CITY OF ALBUQUERQUE

January 25, 2017

Re: 3901 Masthead NE
Request for Certificate of Occupancy- Transportation Development
Engineer's/Architect's Stamp dated 08-31-16 (D17-D095)
Certification dated 01-19-16

NORTH  
 SITE DEVELOPMENT  
 PLAN FOR  
 BUILDING PERMIT  
 JUNE 09, 2005 SCALE: 1" = 30' (U.N.O.)

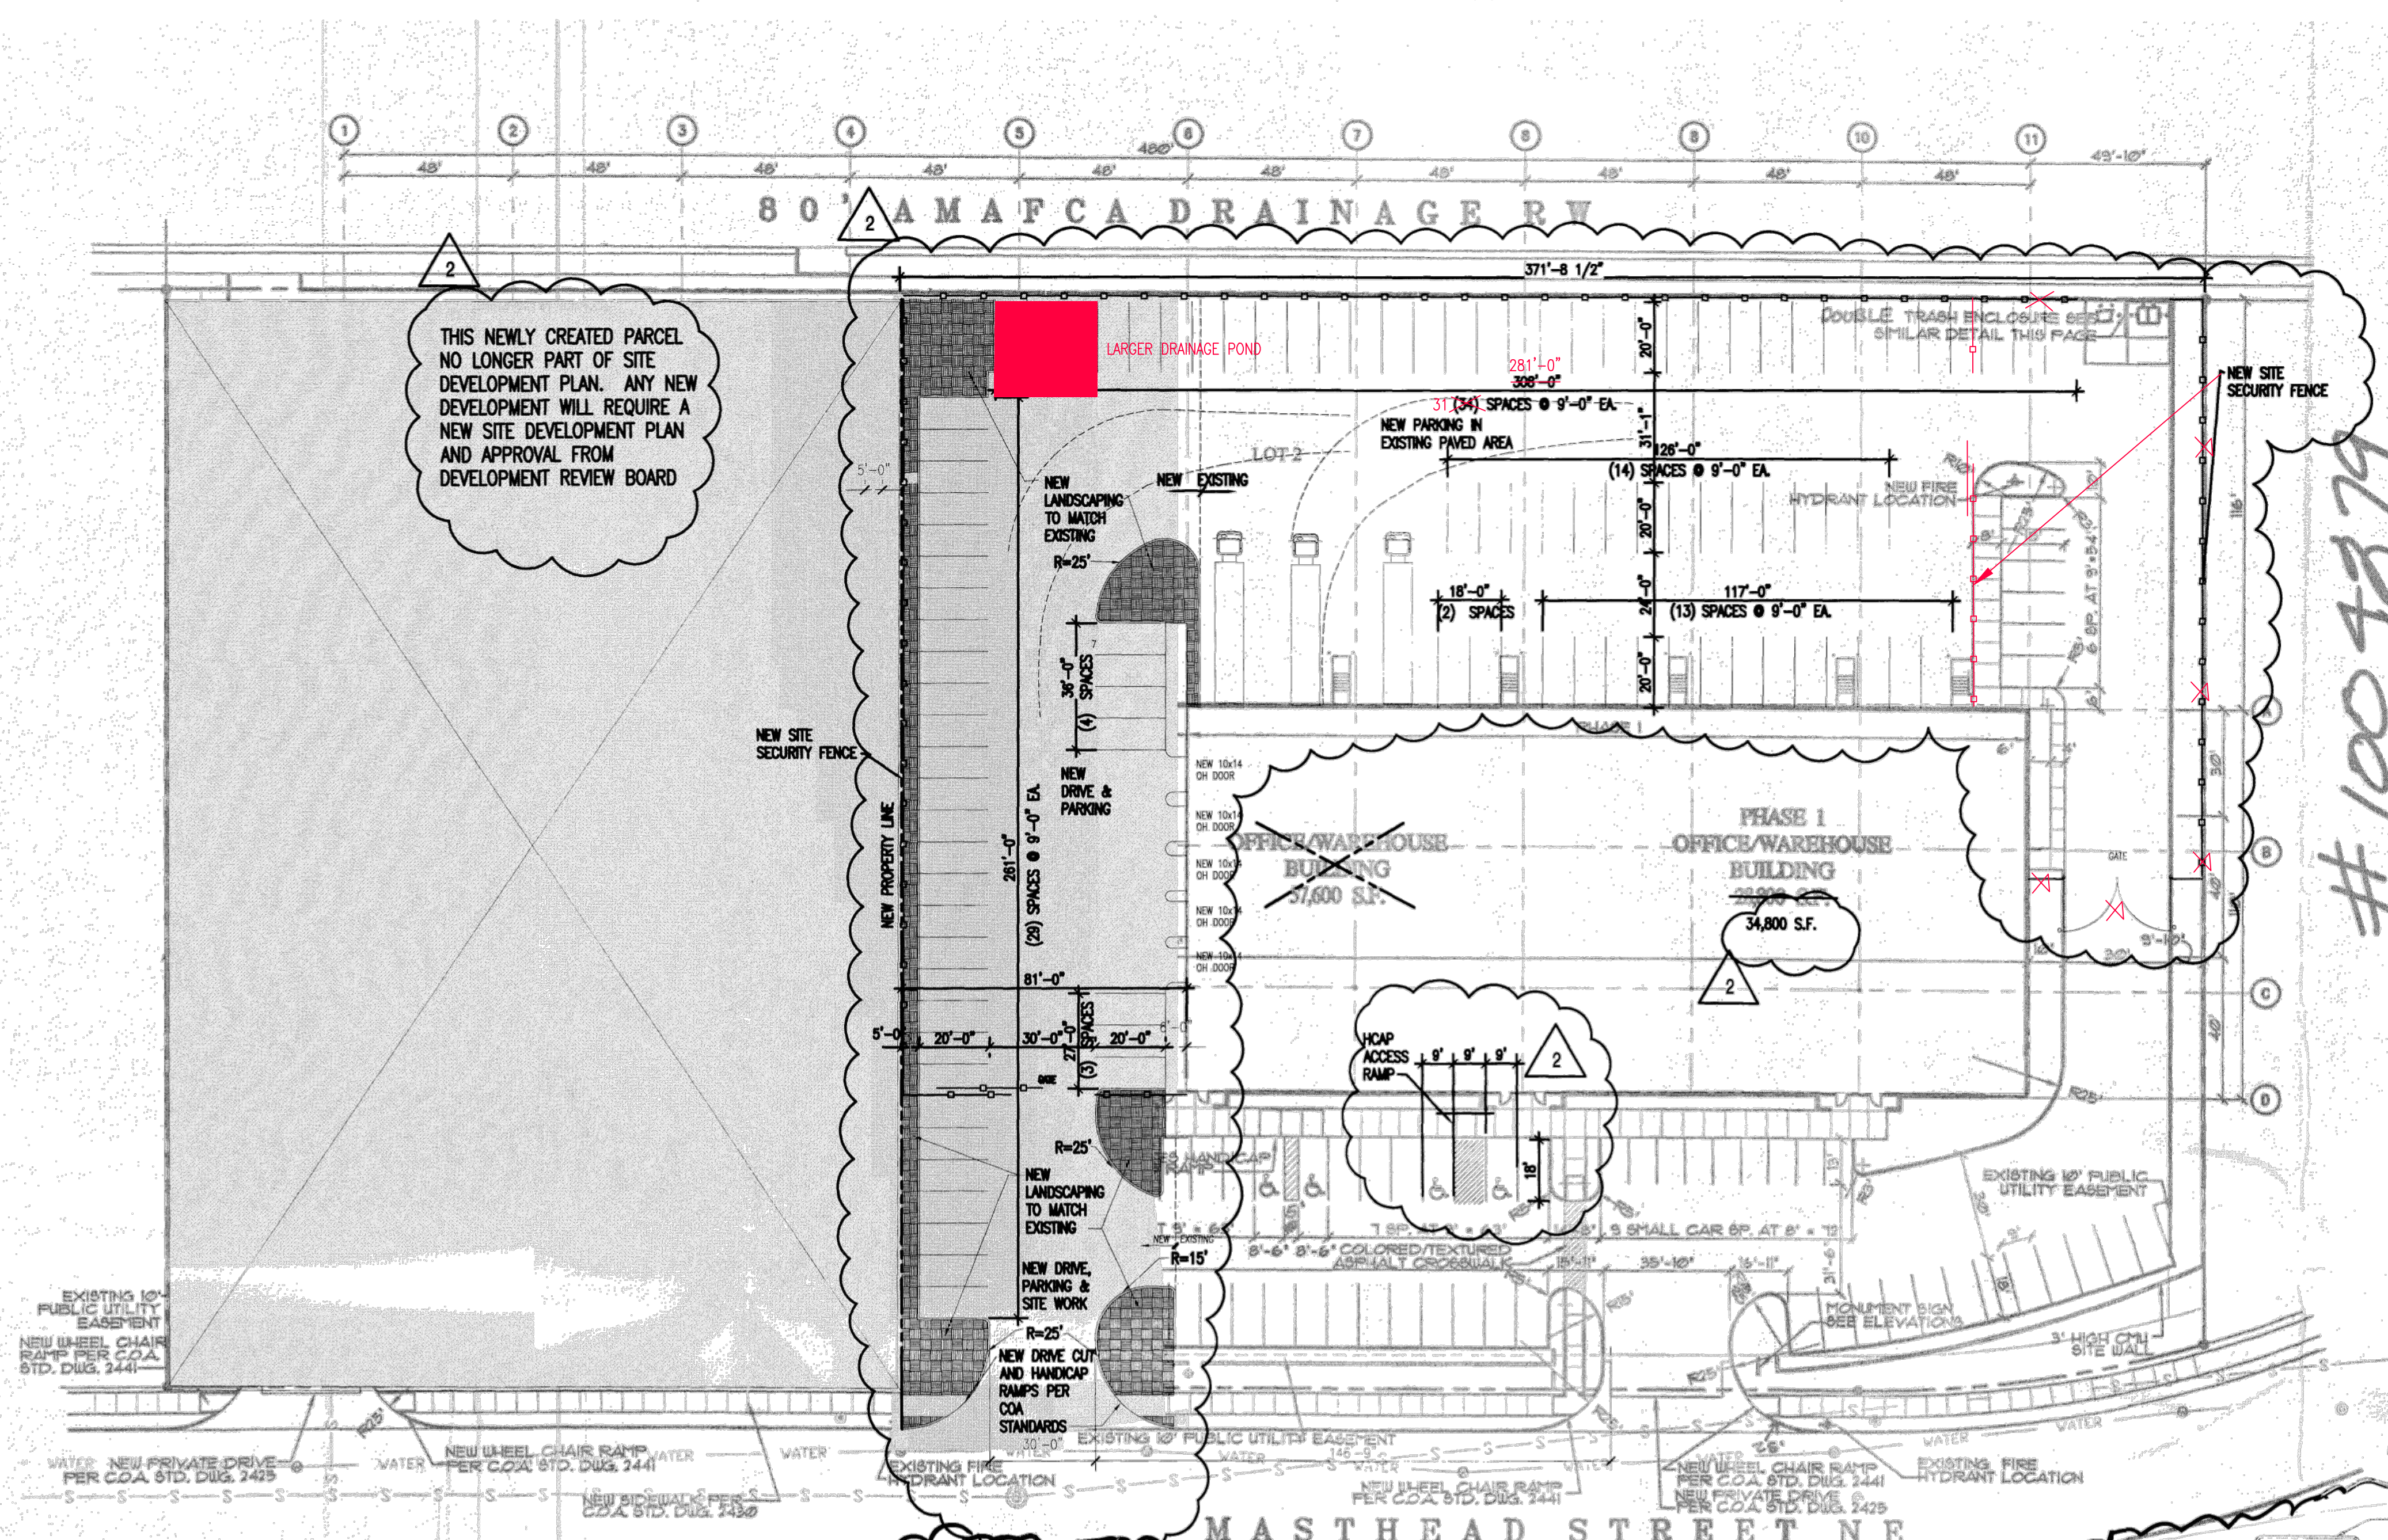
- Truncated domes (detectable warning surfaces) need to extend the full width of the curb ramp. The truncated domes at the West entrance are improperly installed.

- The plan call for the curb ramps at the East entrance to be reconstructed. This will require the ramps to meet current ADA standards and have truncated domes.

- The van accessible handicap parking at the front entrance needs to have the ADA curb ramp to allow access to the building. ADA accessible pedestrian pathway should not be placed behind parking space or adjacent to a vehicular way. Vehicle and pedestrian/wheel chair conflicts should be avoided as much as possible.

- The parallel parking stalls on the east side of the lot are not indicated on the plans. The added parking spots prevent two-way traffic, by reducing the aisle width below 24 feet.

- The parking spot between the West gate and the key pad should be striped to prevent parking in that spot. This will reduce vehicle conflicts.
